**A38 Derby Junctions**  
**TR010022**

**8.91 Applicant's Responses to Information  
or Submissions Received by Deadline 8**

**Applicant's Responses to Information or Submissions  
Received by Deadline 8**

<b>Regulation Number</b>	Rule 8(1)(k)
<b>Planning Inspectorate Scheme Reference</b>	TR010022
<b>Document Reference</b>	TR010022/APP/8.91
<b>Author</b>	A38 Derby Junctions Project Team, Highways England

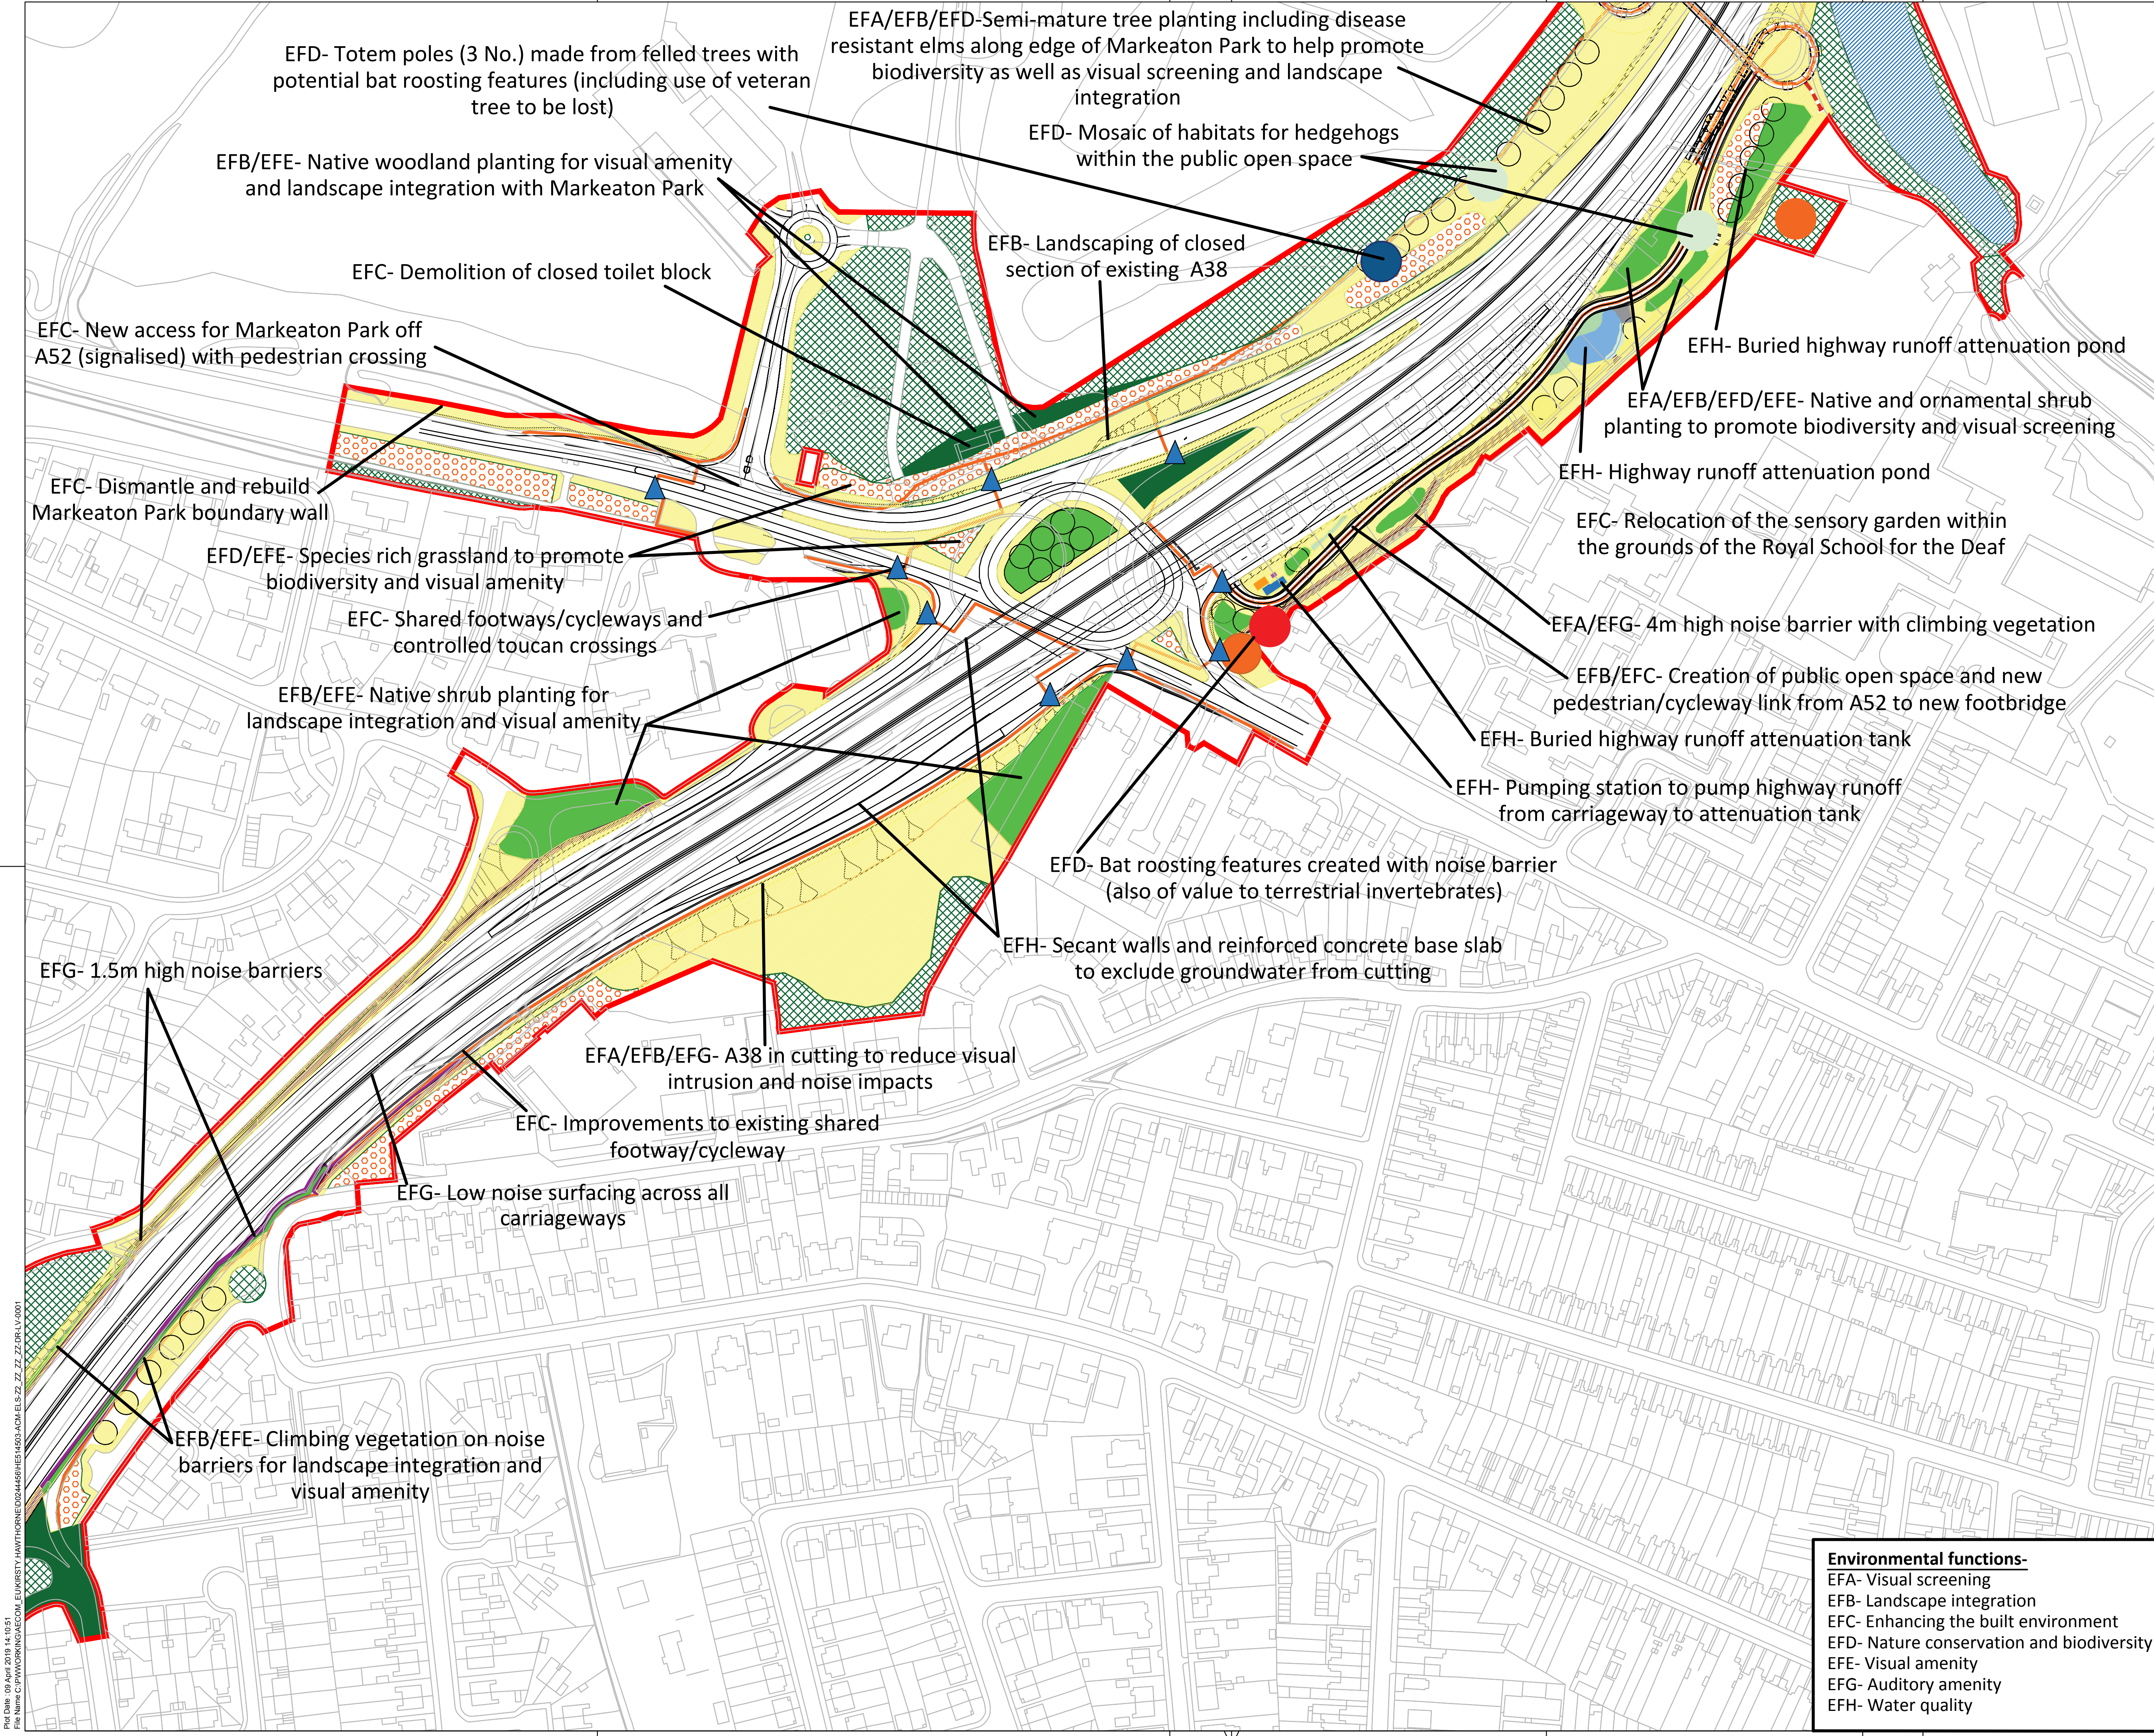
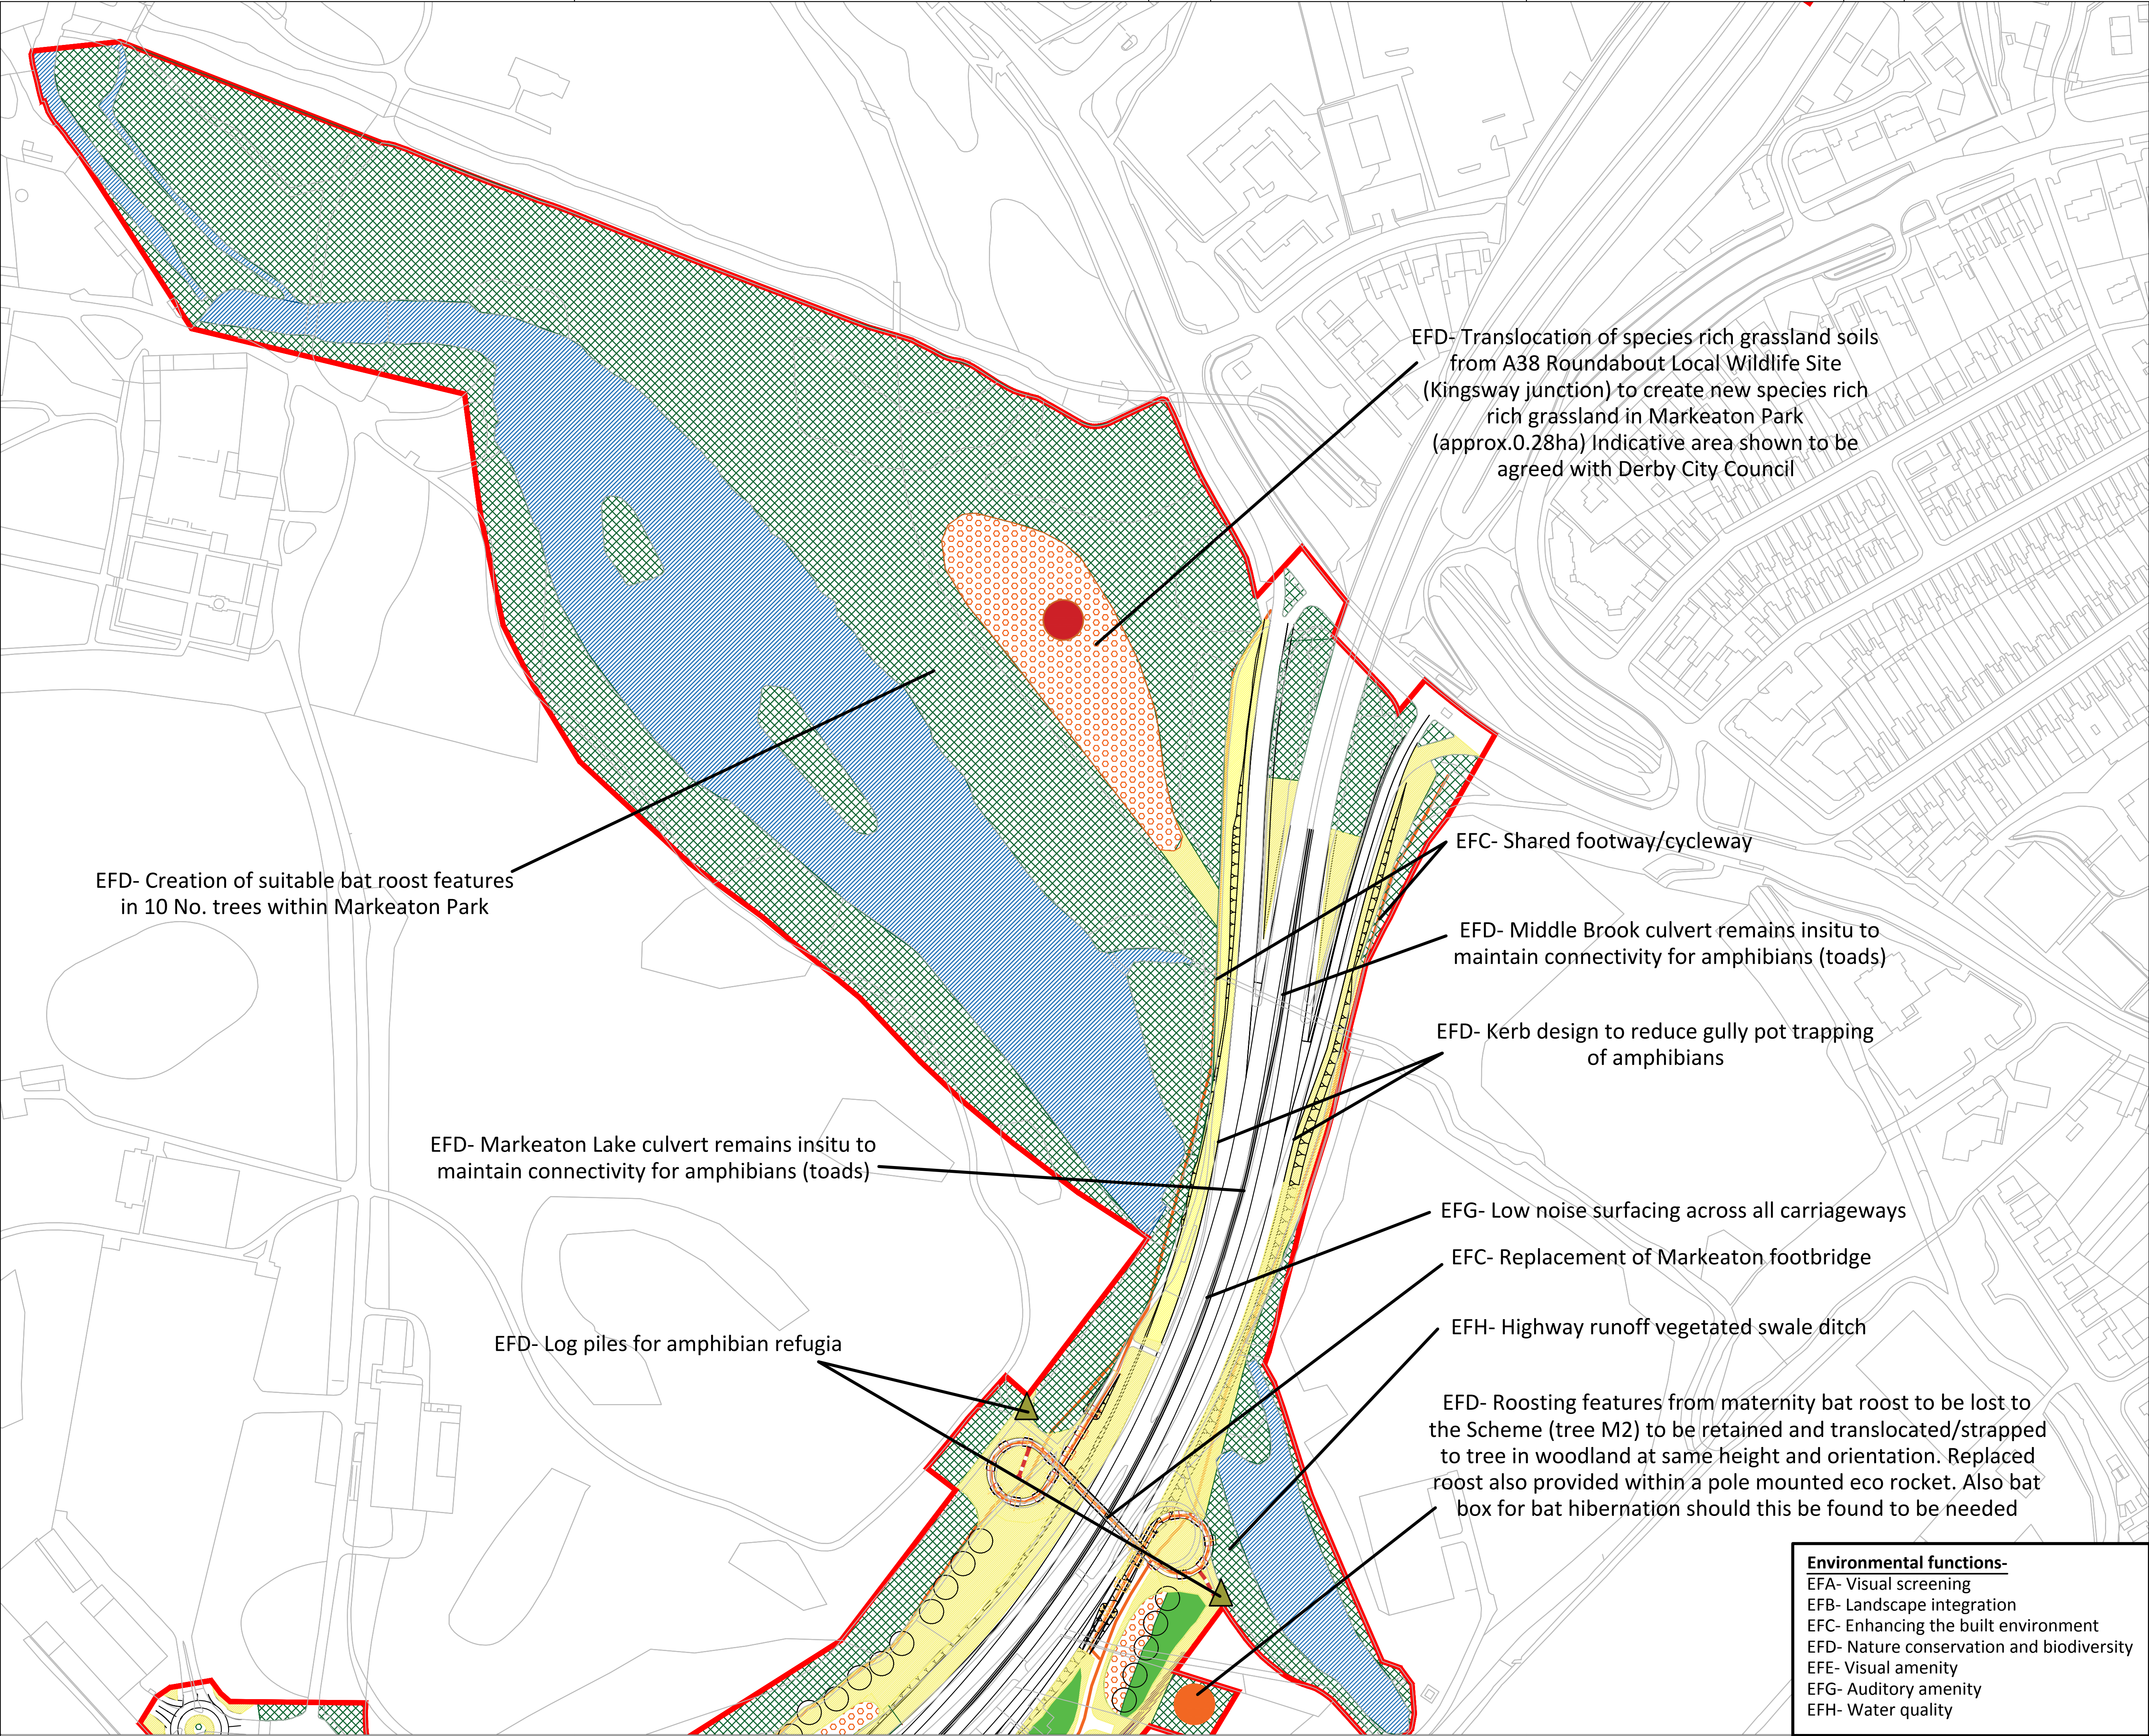
Source	Comment	Applicant's Response
	<p>The Proposed mitigation has not been shown to have equal environmental value, and is unlikely to show any net gain.</p> <p>The mitigation saplings cannot absorb the same amounts of Carbon dioxide as trees and hedging that grow millions of leaves.</p> <p>Semi-mature disease-resistant Elms are to be planted very close to the newly dug diverted utilities corridor. Won't they be disturbed if the any of the diverted utilities have to be inspected for preventative maintenance or for upgrade or repair?</p> <p>If one of the utilities in that corridor needs the repair when one of the trees turned into a totem pole there is successfully used as maternity bat roost, what a dilemma as the penalties per bat disturbed clash against penalties for loss of the service of that utility.</p>	<p>A wide range of ecological mitigation measures have been integrated into the Scheme design – these are illustrated in the Environmental Masterplans (ES Figures 2.12A and 2.12H) [APP-068]. Such mitigation measures have been defined in consultation with key ecology stakeholders, including the local authorities, Natural England, the Environment Agency and Derbyshire Wildlife Trust. Taking into account the defined mitigation strategy, ES Chapter 8: Biodiversity [APP-046] provides details of the Scheme effects during both construction and operation. This chapter reports a moderate adverse significant effect (at the County or Unitary Authority scale) on the A38 Kingsway Roundabout Local Wildlife Site (LWS) due to complete permanent loss of this LWS. However, there is potential for there to be up to a moderate beneficial significant effect (at the County or Unitary Authority scale) on biodiversity in the medium to long term; particularly on standing water (ponds), running water, foraging and commuting bats, otter, terrestrial invertebrates, aquatic invertebrates and fish.</p> <p>For NSIPs such as the Scheme, there is no explicit requirement to demonstrate no net loss or net gain. Nevertheless, the Scheme has sought to maximise opportunities for enhancement in biodiversity associated with defined mitigation measures.</p>

Source	Comment	Applicant's Response
		<p>During the development of the Scheme design, Highways England has sought to minimise the loss of existing trees, and where such losses are unavoidable, mitigation planting is proposed as indicated in the Environmental Masterplan figures (ES Figure 2.12A to 2.12H [APP-068]). Land use changes associated with the Scheme have been taken into account by the climate assessment as reported in ES Chapter 14:Climate [APP-052]. It is acknowledged that newly planted trees will take time before they are able to take up as much carbon dioxide as mature trees. This has been taken into account by the carbon impact assessment.</p> <p>With regard to the trees planted in the vicinity of the utilities corridor along the edge of Markeaton Park (including the proposed disease-resistant elms), these will be planted back from the repositioned utilities such that should any future utilities work be needed, the planted trees will not be affected. The same is true of the three totem poles to be formed with felled trees – these too will be set back from the utilities corridor such that any future utilities works will not disturb them.</p>
